GG 119 Road Safety Audit Response Report

Project Details <i>(To be completed by Design Organisation)</i>	<i>New simple priority T-junction for access to new development. New & upgraded pedestrian infrastructure for direct and improved connectivity. Associated boundary works, ducting, drainage, earthworks, road pavements, kerb realignment and various street furniture amendments.</i>
---	---

1.0 Project Details <i>(To be completed by Design Organisation)</i>			
Report Title	A643 Westgate – Section 278.	Stage of RSA	Stage 2
Date	13/11/2024	Scheme Ref No.	QD1776 / 23-285-002.02
Prepared By	Queensberry Design Ltd.	On behalf of:	Kirklees Council

Drawing Number: **QD1776-1100-11**

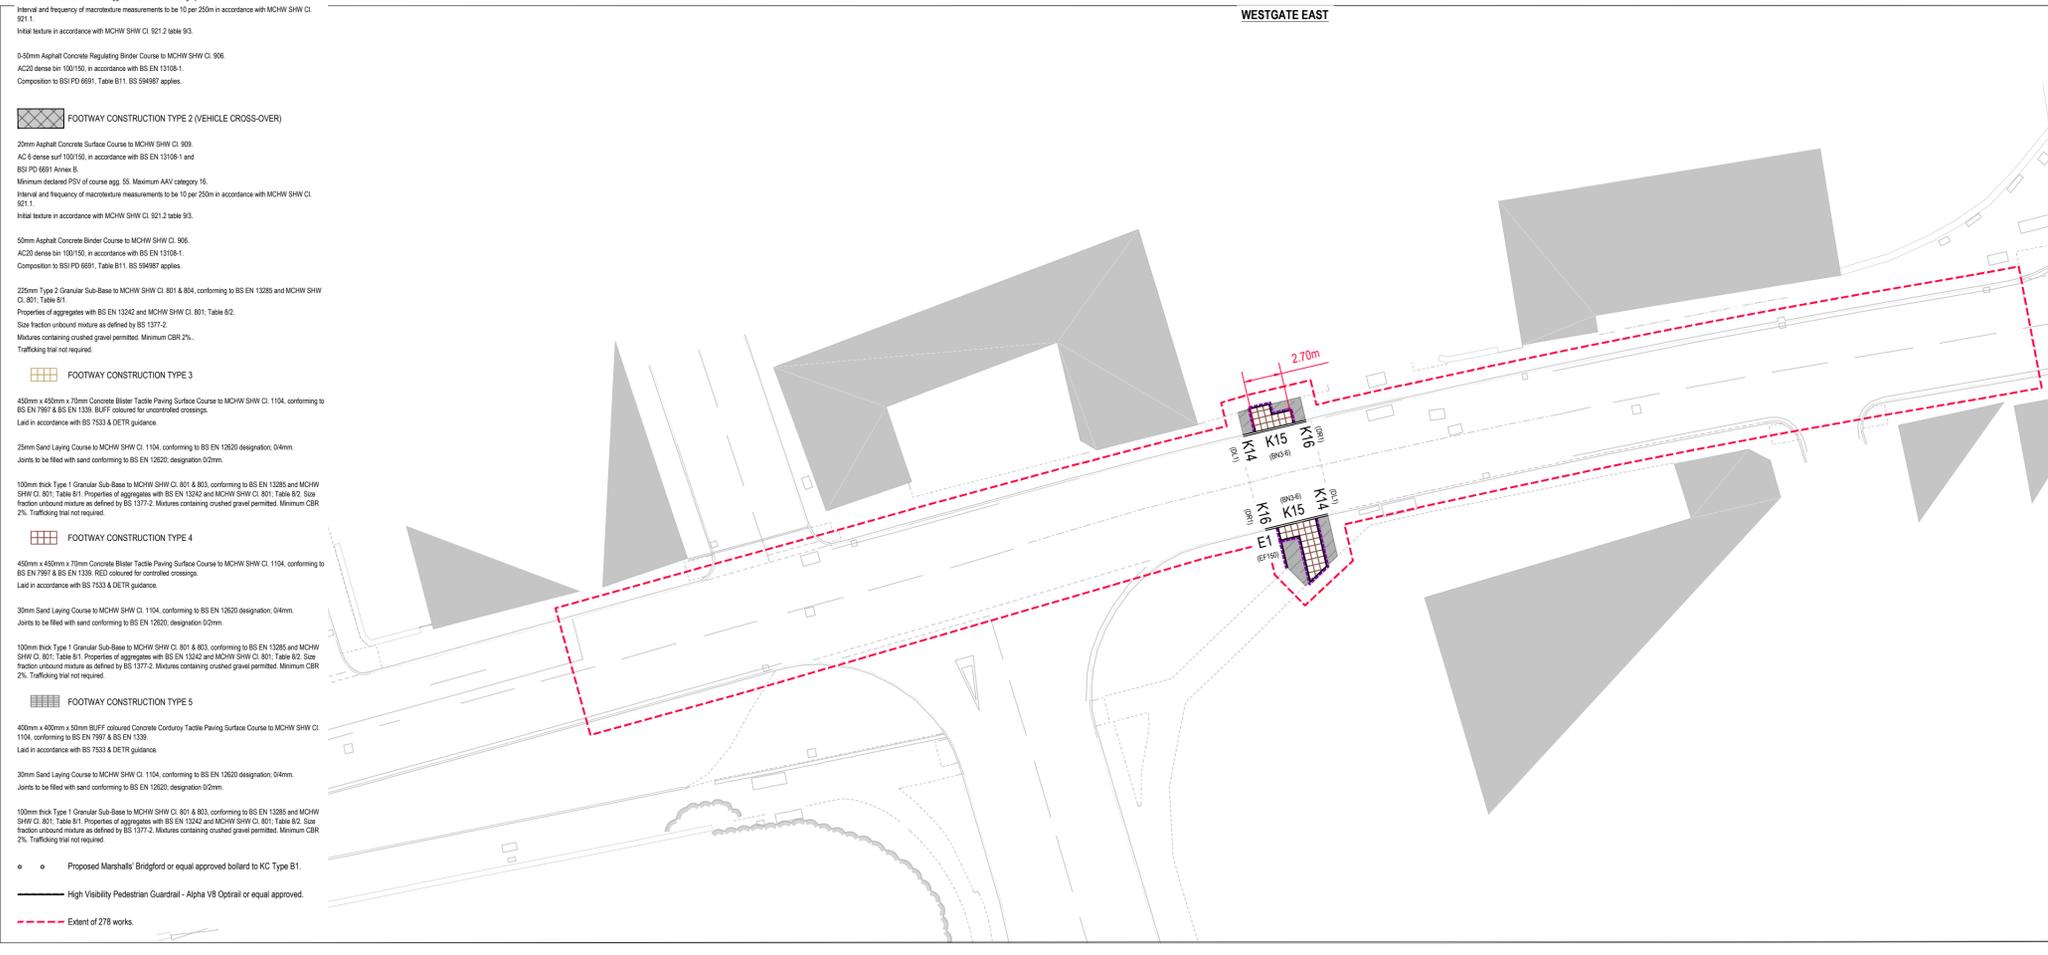
(1) RSA Problem	(2) RSA recommendation	(3) Design Organisation Response (see also Note 1)	(4) Overseeing Organisation Response	(5) Agreed RSA Action
<p>Problem: A Location: Junction of Westgate and Quarry Road Summary: Tactile paving is shown on the western radius of the junction of Westgate and Quarry Road. There is an existing road sign within the existing tactile paving and a low wall which encroaches over the existing tactile arrangement. Part of the proposed tactile paving layout appears to be located under the existing wall and the presence of these obstacles presents a risk to visually impaired pedestrians and increases the risk of trips and falls. The crossing across Quarry Street is an inline crossing and is an insufficient depth to warn visually impaired pedestrians the presence of the carriageway. The alignment of the crossing will need to be checked on site to ensure that the proposed tactile paving lines up with the existing tactile paving on the eastern side of the junction or these are amended as necessary.</p>	<p>Recommendation: Provide a safe width and depth of tactile paving to the western side of Quarry Road at the junction with Westgate.</p>	<p style="text-align: center;"><i>Disagree.</i></p> <p><i>The proposed tactile paving is intended to avoid the existing road sign and wall whilst aligning as closely as possible with the existing tactile paving on the opposite side of the junction. Though it is accepted that a min. 1200mm depth would be applicable, the 800mm shown matches the existing installation opposite and elsewhere in the vicinity and is therefore thought to be more suitable in this instance to reduce the risk of further confusion.</i></p> <p><i>The design drawings' presentation may be improved or annotated further for clarity where applicable.</i></p>	<p>Agree with Auditor's recommendations and Reject Design Organisation's Response.</p> <p>The tactile paving should be three blocks deep here, the Auditors are correct. Whether it is wrong elsewhere or not nearby, is irrelevant. Propose the paving on the opposite side three blocks deep as well, because it's part of the same</p>	<p>The RSA recommendations are to be implemented.</p> <p>Full tactile paving replacement to standard, realigned on both sides to ensure safe alignment through junction is now incorporated within the proposed design.</p>

<p>Problem: B Location: Footpath connection from the Site onto Brick Street Summary: The proposed upgraded footpath connection between the site and Brick Street will increase the risk of collisions between motorised and non-motorised users. The proposed upgraded length of footpath between the footpath link into the development and Brick Street without any form of control will lead to an increased risk of motorised users using the footway and increased risk of collisions with pedestrians. At the point the upgraded length of footway meets the carriageway of Brick Street there are no measures to warn visually impaired pedestrians that they are entering a carriageway. This will lead to an increased risk of collisions between visually impaired users and motorised users.</p>	<p>Recommendation: Provide measures to prevent motorised users from using the footpath from Brick Street and to assist visually impaired users.</p>	<p><i>Accepted – but with alternative solution.</i></p> <p><i>A footpath has been proposed linking the development to the road section of Brick Street as requested by Kirklees PRow officer. As Brick Street and the continuing unmade track to the south is private, Strata have no jurisdiction to undertake any works outside of the 1.2m wide PRow - which is the width of the footpath shown - and therefore no capability to propose installation of any vehicle deterrent without it impacting the usable PRow.</i></p> <p><i>However, it is proposed to incorporate corduroy hazard warning paving to alert visually impaired users of joining a route shared by other users i.e. motor traffic.</i></p>	<p>Agree with Auditor's recommendations and Reject Design Organisation's Response.</p> <p>If it would be possible for traffic to use this pedestrian route to access the new estate, safety measures must be taken to prevent it, regardless of land ownership issues. Provide bollards or similar within the confines of the development and where the footpath ends and make whatever changes would be necessary to the layout around that location. Corduroy hazard warning paving cannot be used to warn visually impaired people of traffic under any circumstances. Consult with PRow Kirklees Council for revised design after these recommendations are implemented.</p>	<p>The RSA recommendations are to be implemented.</p> <p>Bollards to prevent vehicular access are now incorporated within the proposed design.</p> <p>Corduroy paving may be used in any situation where vision impaired people need to be warned of a hazard and advised to proceed with caution and this has been tested for suitability as a delineator to shared space before successful implementation elsewhere. It is therefore concluded to be the most appropriate treatment here and is now incorporated within the proposed design in combination with a channel kerb for necessary set-back.</p>

<p>Problem: C Location: Northern side of zebra crossing on A643 Westgate Summary: Vegetation and obstructions in the footway to the north of the zebra crossing will increase the risk of pedestrians entering the carriageway into the path of oncoming vehicles resulting in collisions. Vegetation along the back of footway to the north of A643 Westgate encroaches on the footway and reduces the available footway width. The reduced footway width will increase the risk of pedestrians entering the carriageway to pass pedestrians</p>	<p>Recommendation: Ensure that overgrown vegetation along the back of footway is removed.</p>	<p><i>Agree.</i></p> <p><i>Full vegetation removal is already proposed for this area. The available effective footway width is proposed to increase and the number of street furniture obstructions shall be reduced.</i></p> <p><i>The design drawings' presentation may be improved or annotated further for clarity where applicable.</i></p>	<p>Agree with Auditor's recommendations and support Design Organisation's response.</p> <p>Overgrown vegetation along the back of footway to be removed and cleared.</p>	<p>The RSA recommendations are to be implemented.</p> <p>The proposed design drawings now better clarify the required vegetation removal.</p>
